Pagham Parish Council considered the following applications at a meeting of its Planning Committee Advisory Group held on 11th January 2022. Under a scheme of delegation dated 4th May 2021, the Clerk makes the following comments on behalf of the Council:

P/168/21/HH 5 West Front Road Pagham PO21 4SY. Erection of single storey rear extension, loft conversion to habitable use and installation of solar panels.

DRAWING TITLE
PROPOSED
SITE PLAN

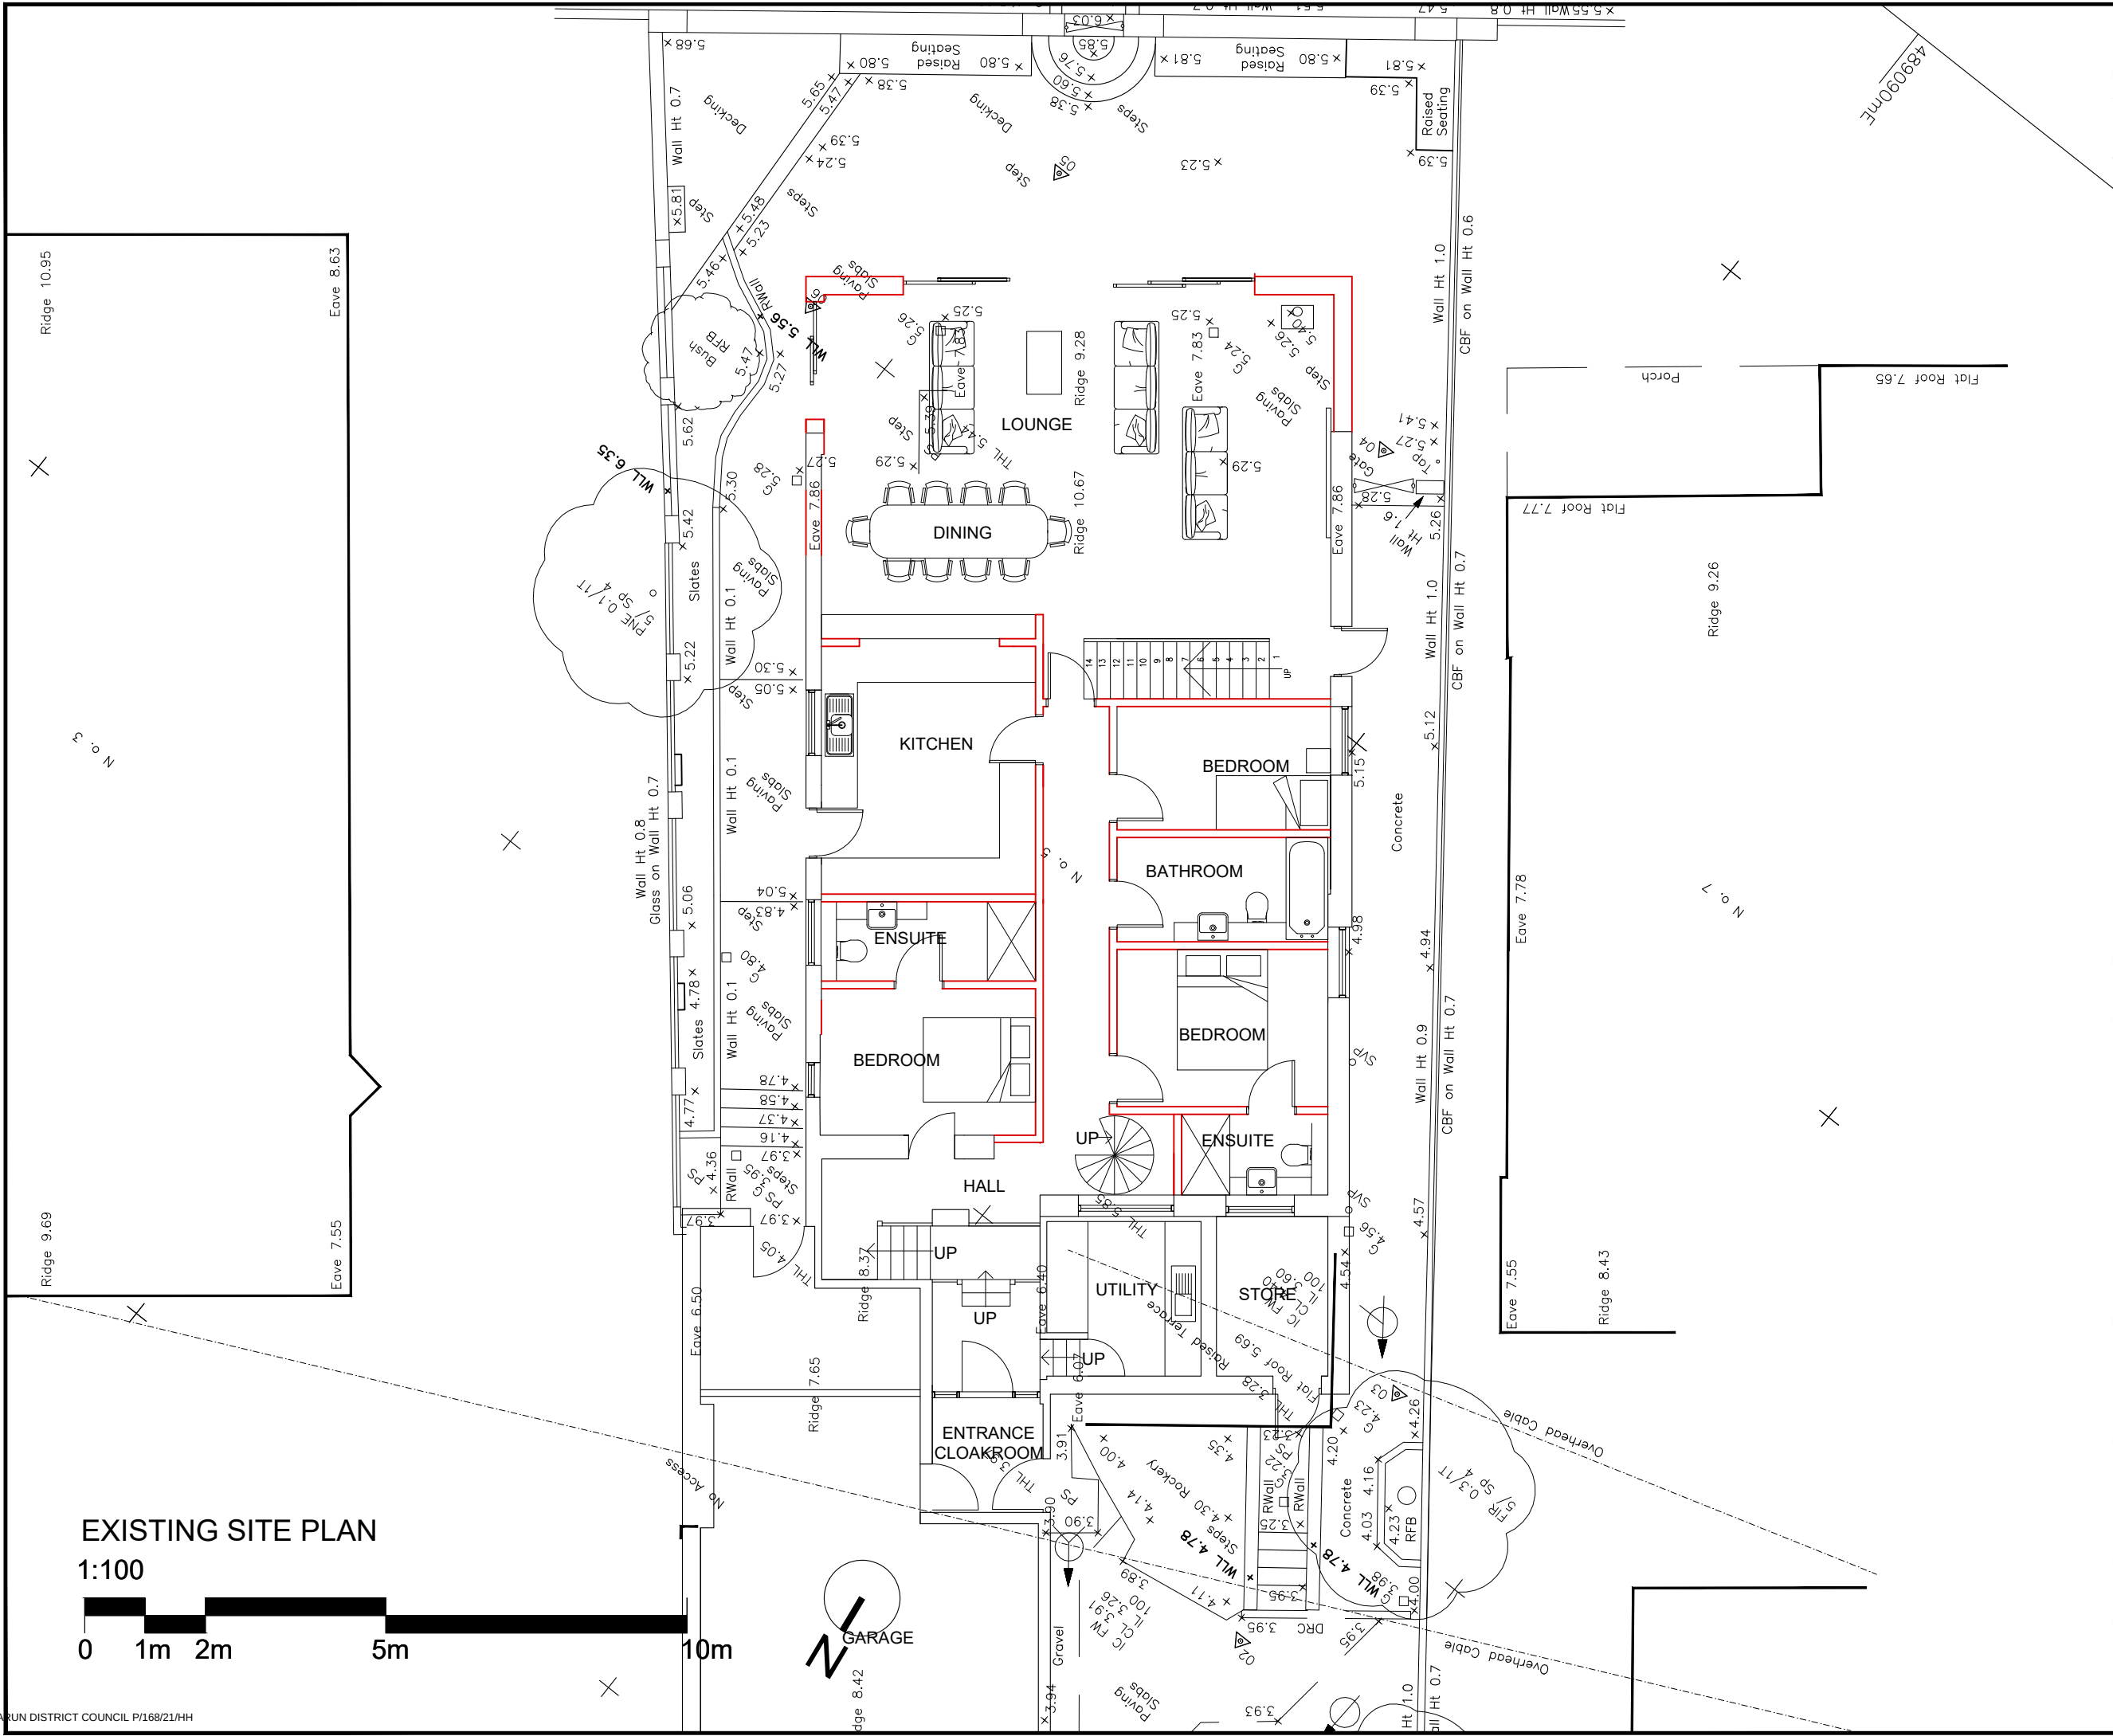
OBJECT. Members felt the site was already overdeveloped and the single storey rear extension would take away from the limited amenity space that remained on the plot. This would leave no room for car parking. Parking on the road or in the vicinity was not adequate. In line with the Pagham Village Design Statement, properties in the Beach Estate should be limited to single storey dwellings to preserve sea views.
